KITTITAS COUNTY COMMUNITY DEVELOPMENT SERVICES

August 10, 2021

Subject: Winemakers Cabins (LPF-21-00007) Final Long Plat – Staff Review, Return of Application- Additional Information Required.

**WINEMAKERS CABINS**

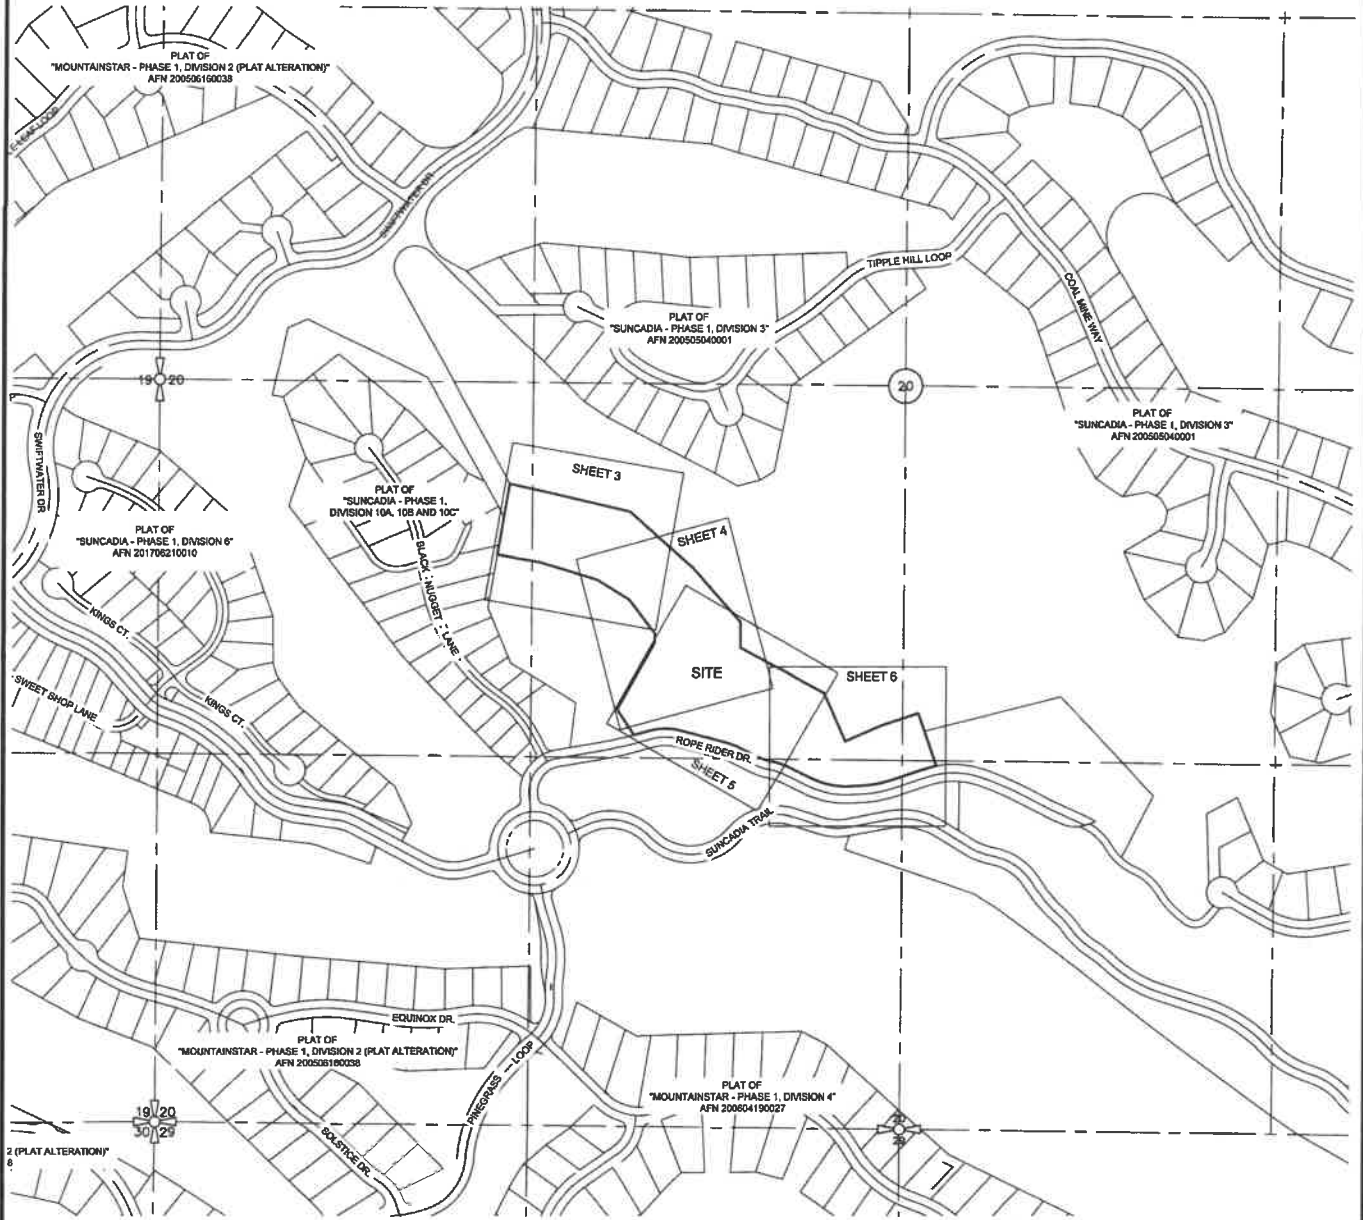
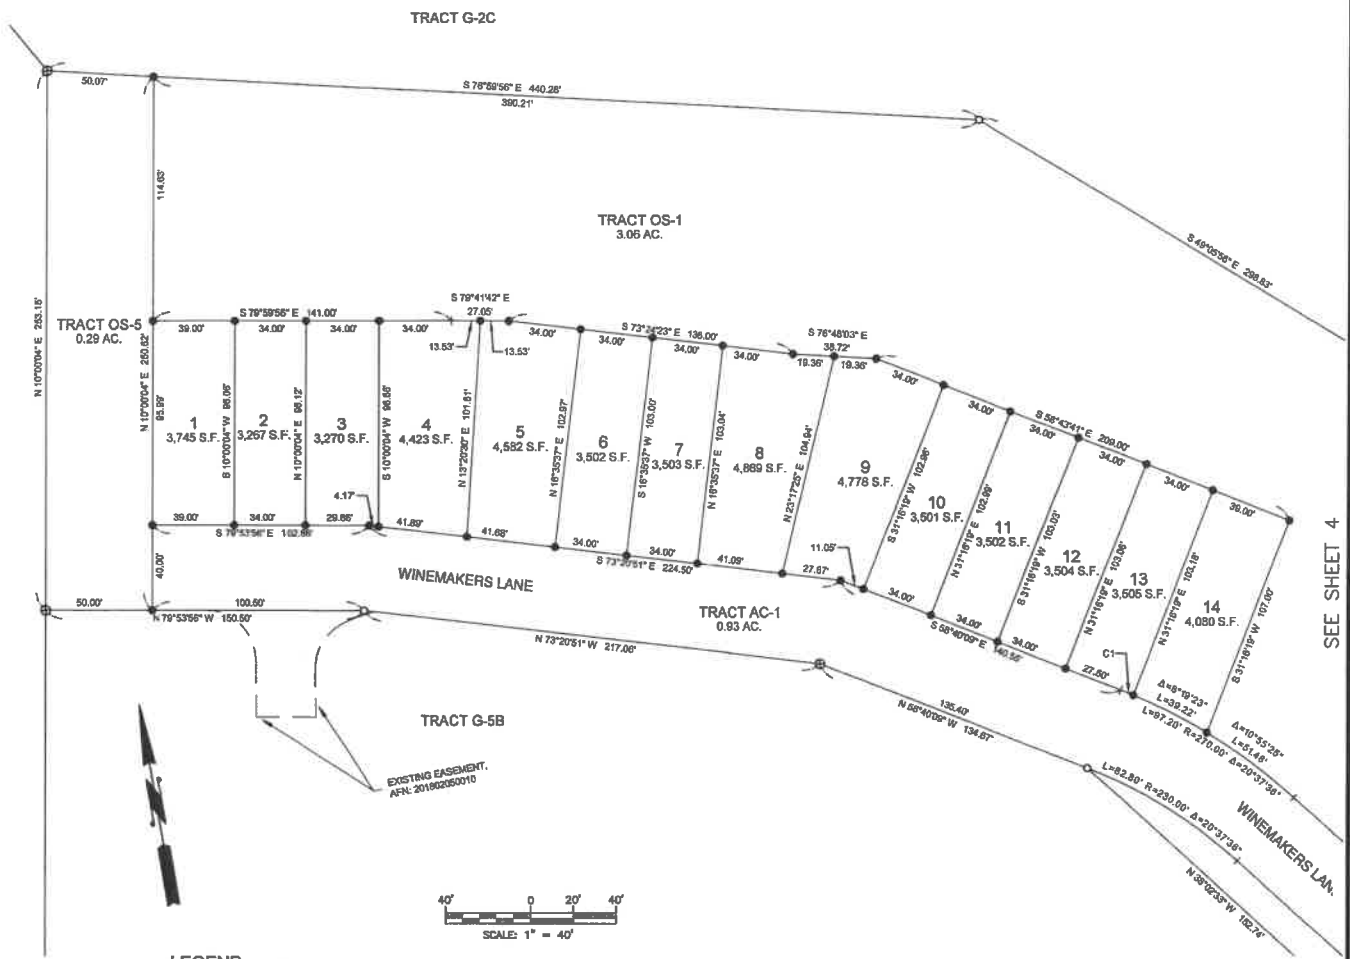
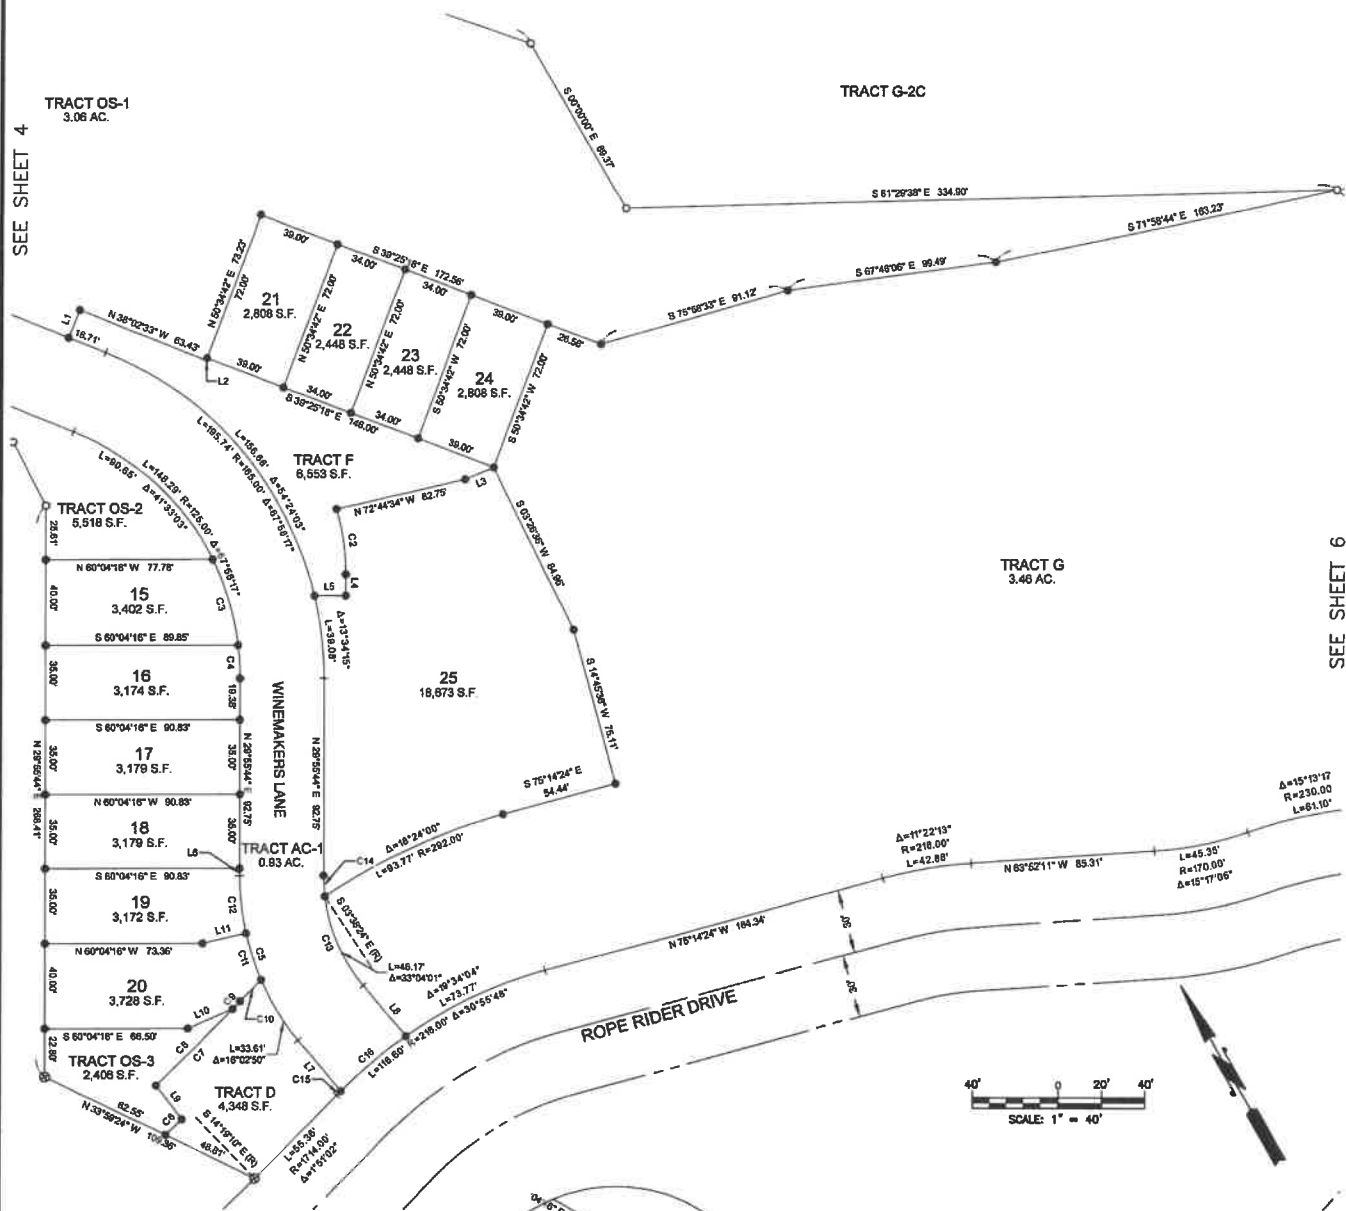
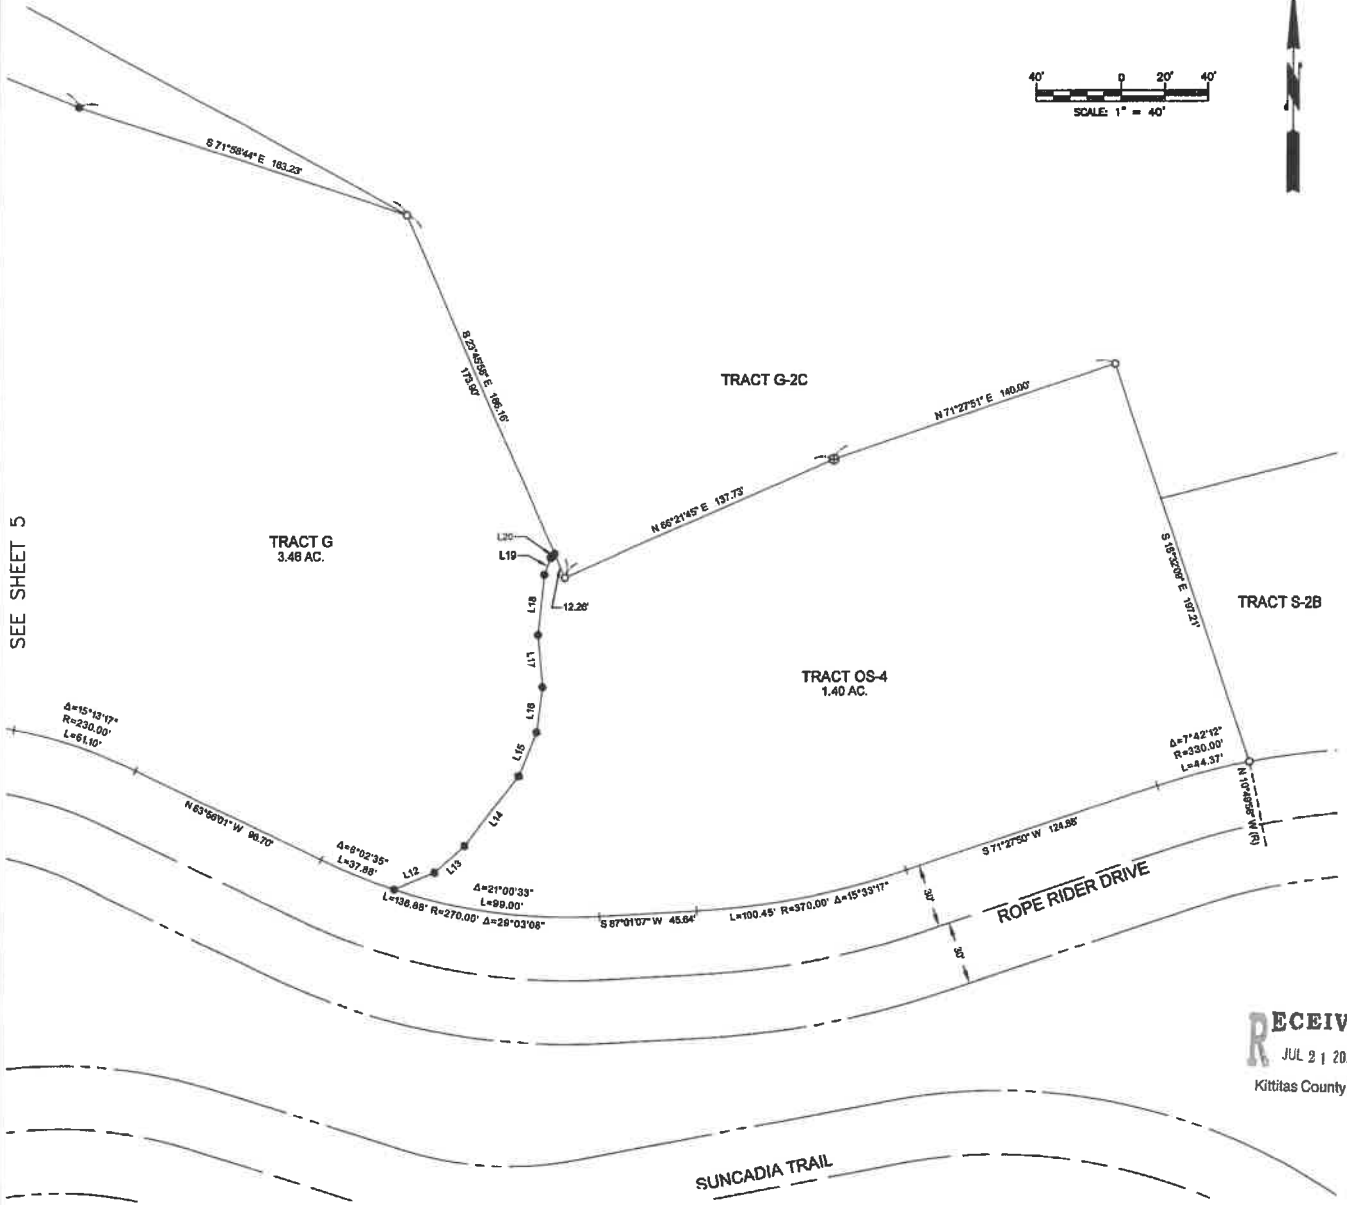
- The final mylars shall note the final plat file number LPF-21-00007 on the face of the plat in addition to the preliminary approval number already noted.
- Taxes on parcel #21909 must be paid in full before final signature.
